4/63/18/NMA

25th July 2018

21, Downview Road, Yapton, West Sussex
Extensions & Alterations
Application No. Y/86/17/HH

No. 62/17/04 'A'

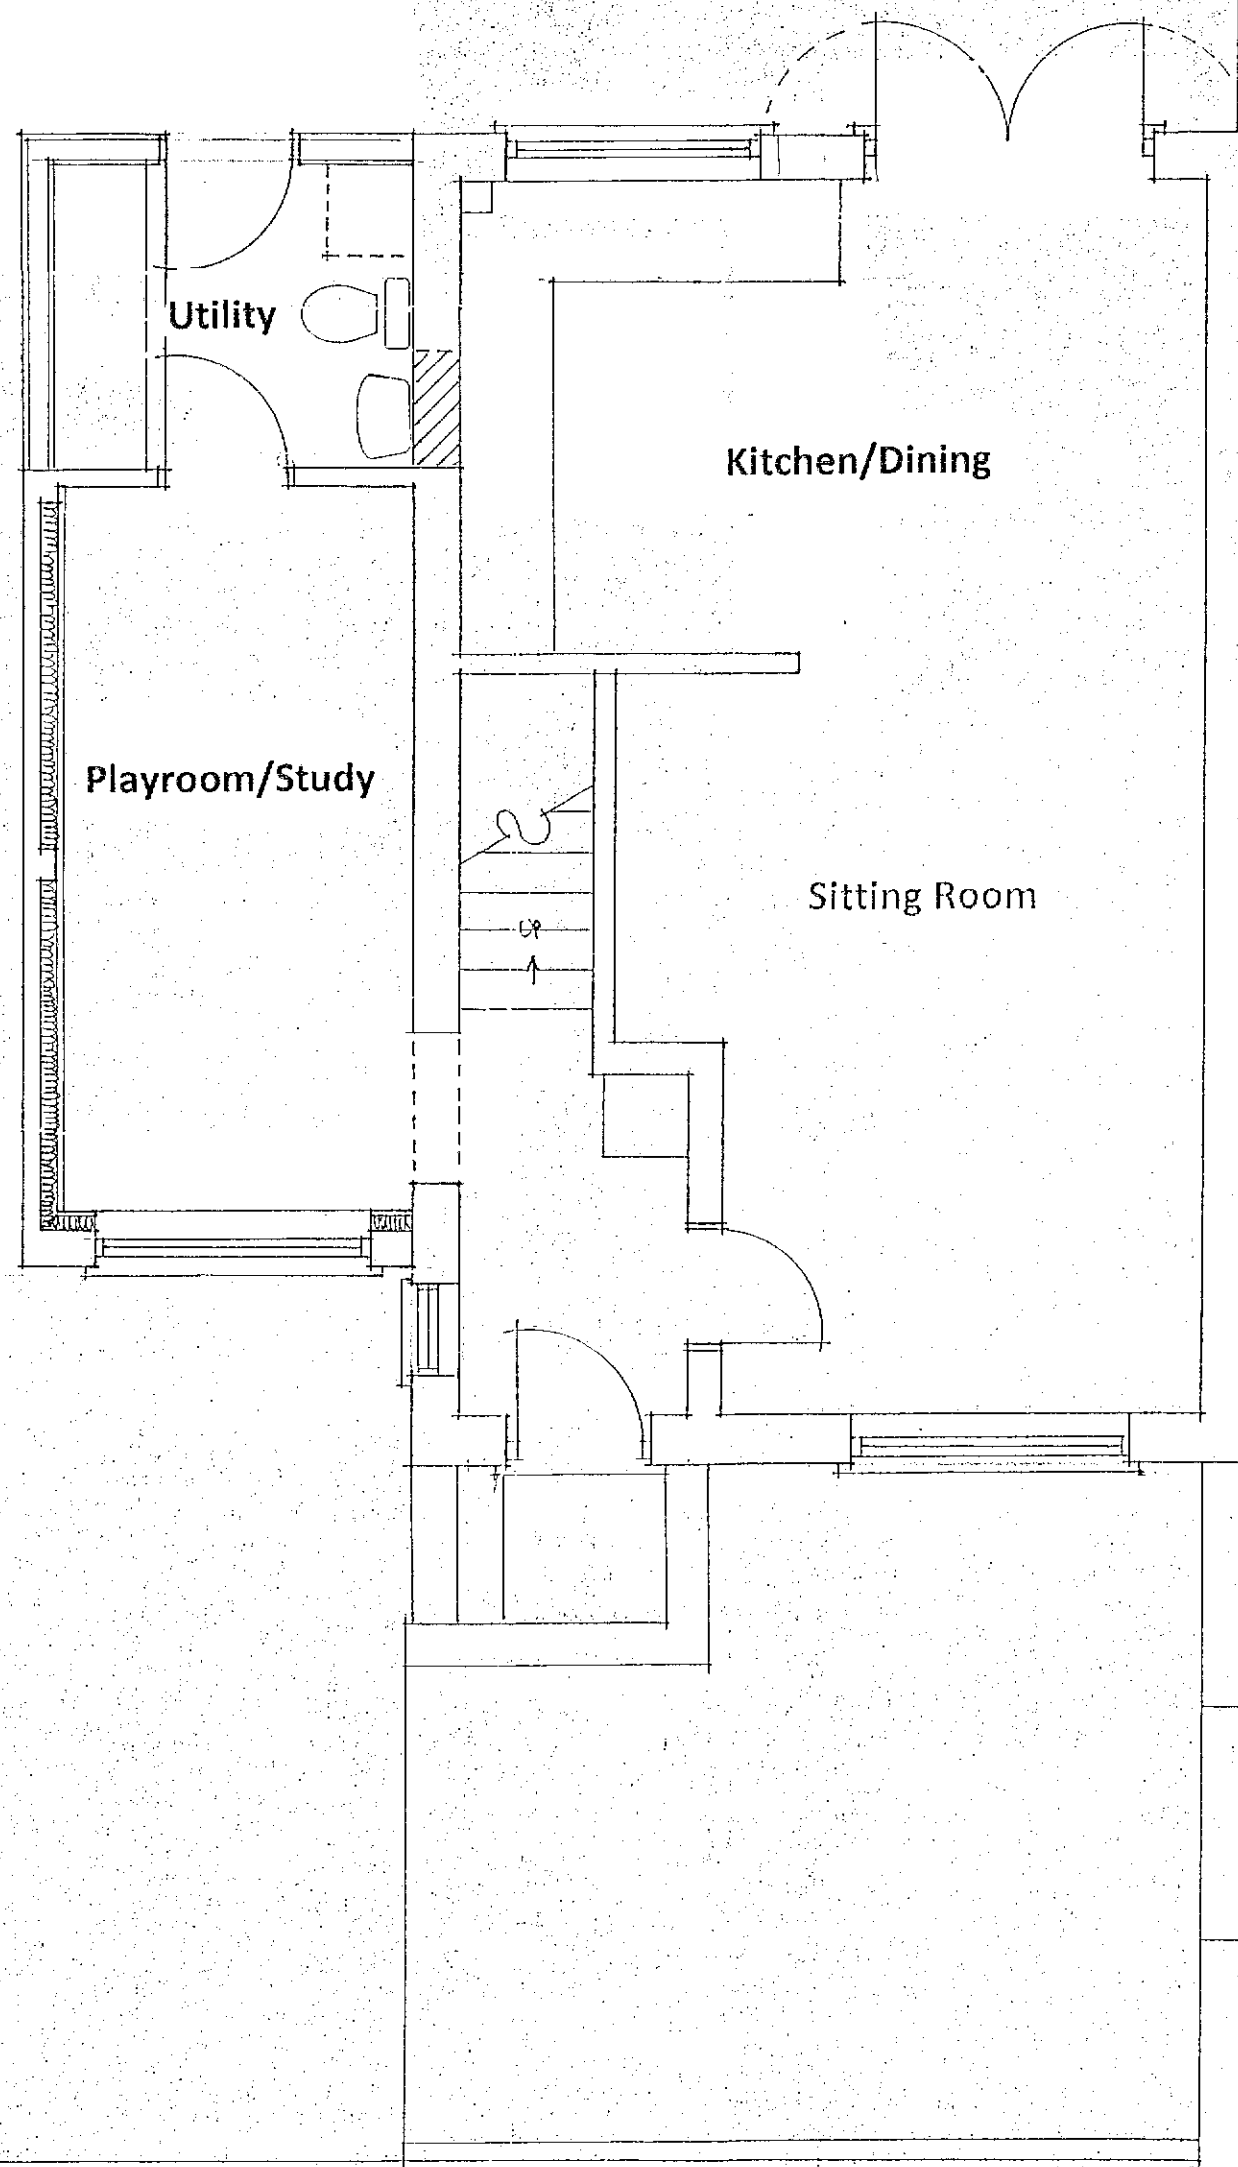
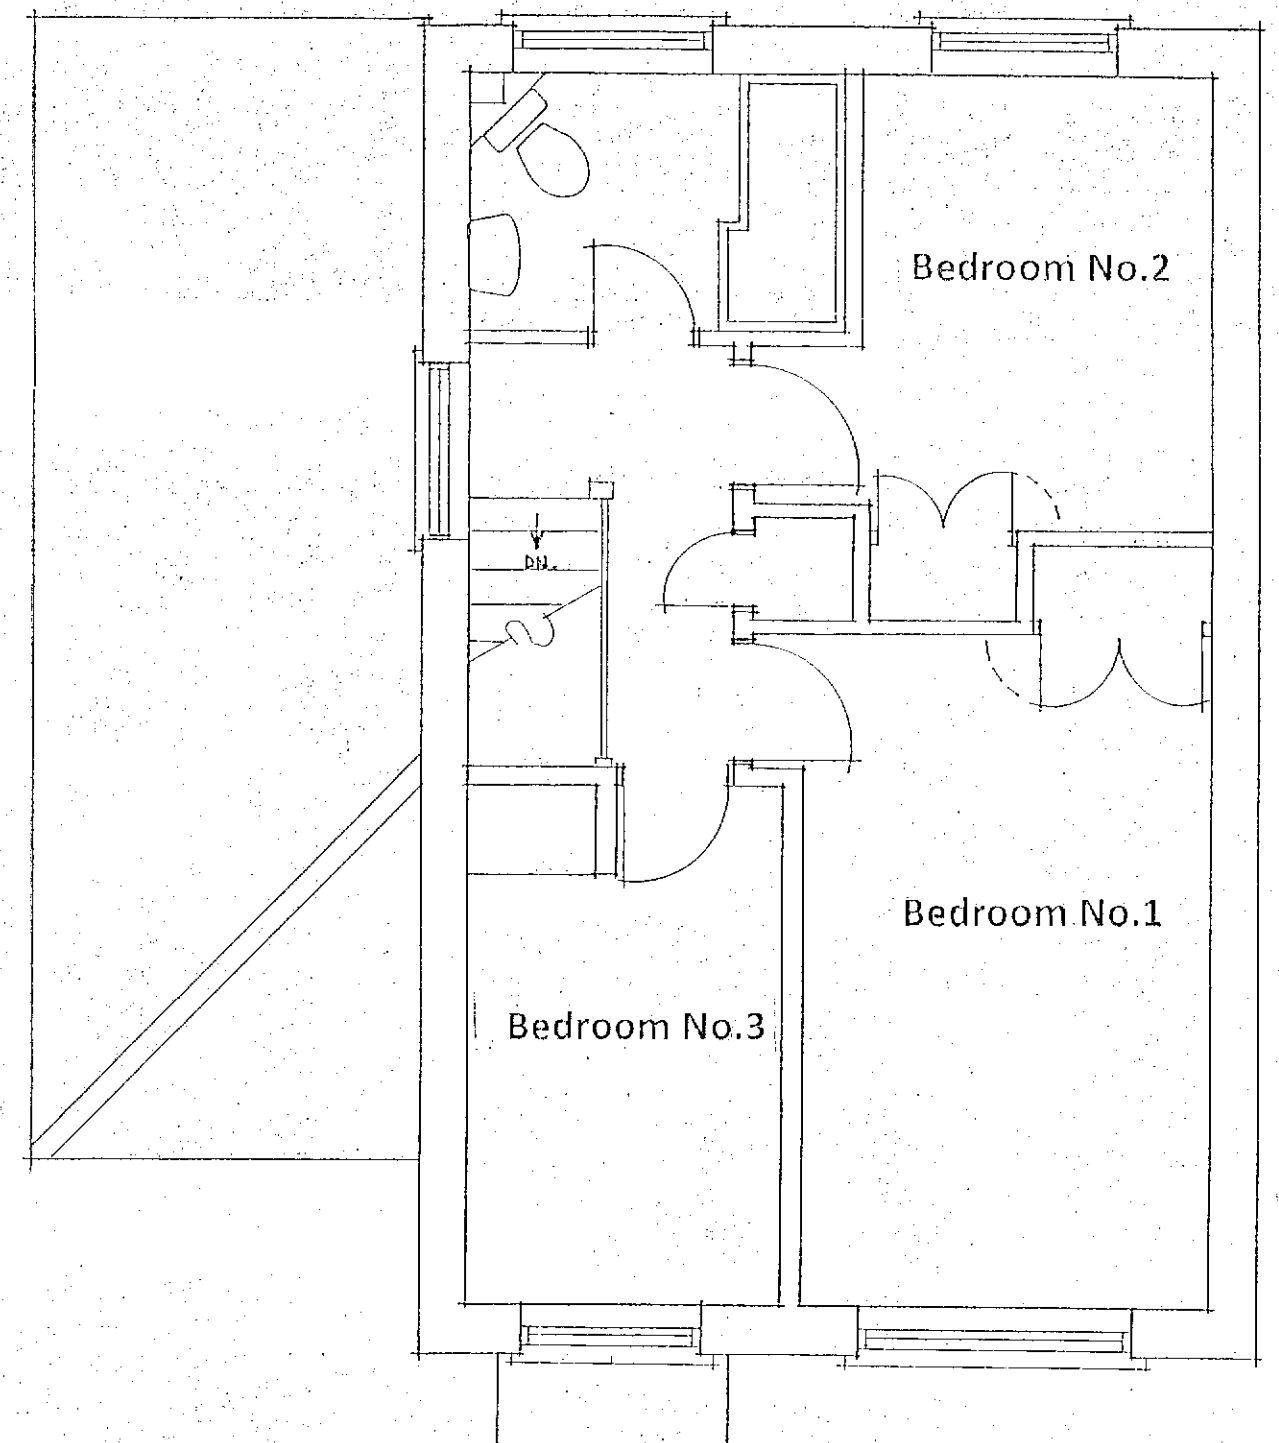
We have therefore redesigned the proposed extension in order that the foundation do not project over the existing public sewer, this has meant that it has been necessary to amend the scheme design & I attach two copies of this revised design. Although the new scheme design is virtually identical to the approved scheme we have lowered the proposed floor level by 300mm & inset the utility room wall by approximately 820mm. All other design features remain the same with the exception of the external cladding which has been changed to vertical cedar boarding.
